**Re: Whataburger at 6100 Alameda Blvd. NE
Erosion and Sediment Control Plan
Engineer's Stamp Date – 6/22/2023 (C18E086C)**

Based upon the information provided in your submittal received 6/23/2023, the above referenced ESC Plan cannot be approved until the following comments have been addressed.

TEMPORARY EROSION AND SEDIMENT CONTROL PLAN

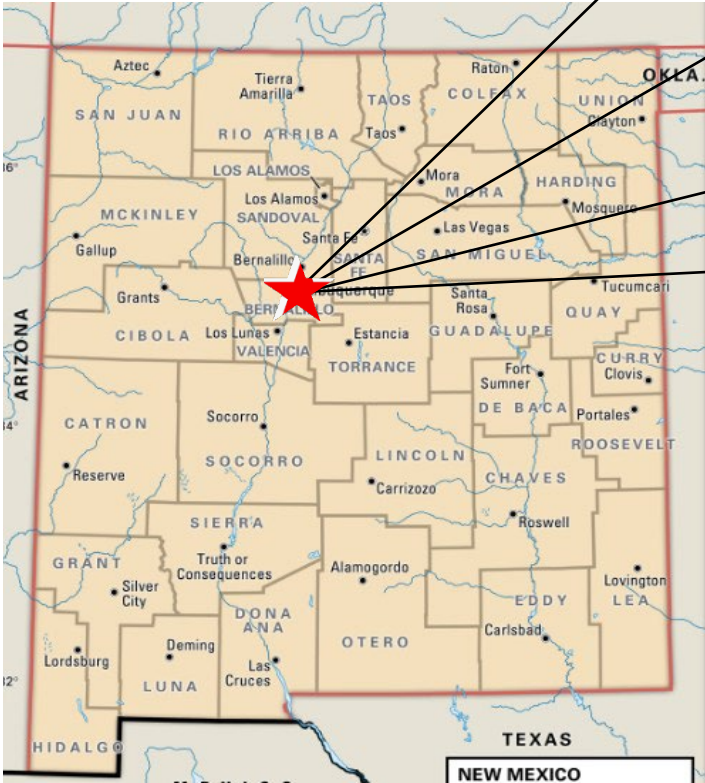
1. The owner information shown on the Information Sheet and the ESC Plan (Whataburger) does not agree with the available Bernalillo County records (Green Jeans West, LLC.) , and the NPDES documentation (NOI) is completely missing. Property rights may have changed hands recently, if so, please provide documentation in the form of a recorded deed or lease. The accurate name and contact information for the entity in control of the property rights is required. The ESC Plan can't be approved for Grading, Building Permit, or Work Order until the property owner's NOI has been reviewed and approved by City Stormwater Quality per Albuquerque Code § 14-5-2-11(a). The NOI must be in the SWPPP and available onsite (CGP7.3).

2. The existing and proposed grades must be shown on the ESC Plan, and they must agree with the Grading Plan approved by Hydrology (CGP7.2.4.b.ii). There may be more comments after the G&D Plan is approved.

3. Identify locations of concentrated flow paths that enter and exit the disturbed areas. Identify locations where sheet flow enters and exits the disturbed area. Show on-site drainage patterns of stormwater before and after major grading activities. (CGP 7.2.4.f)
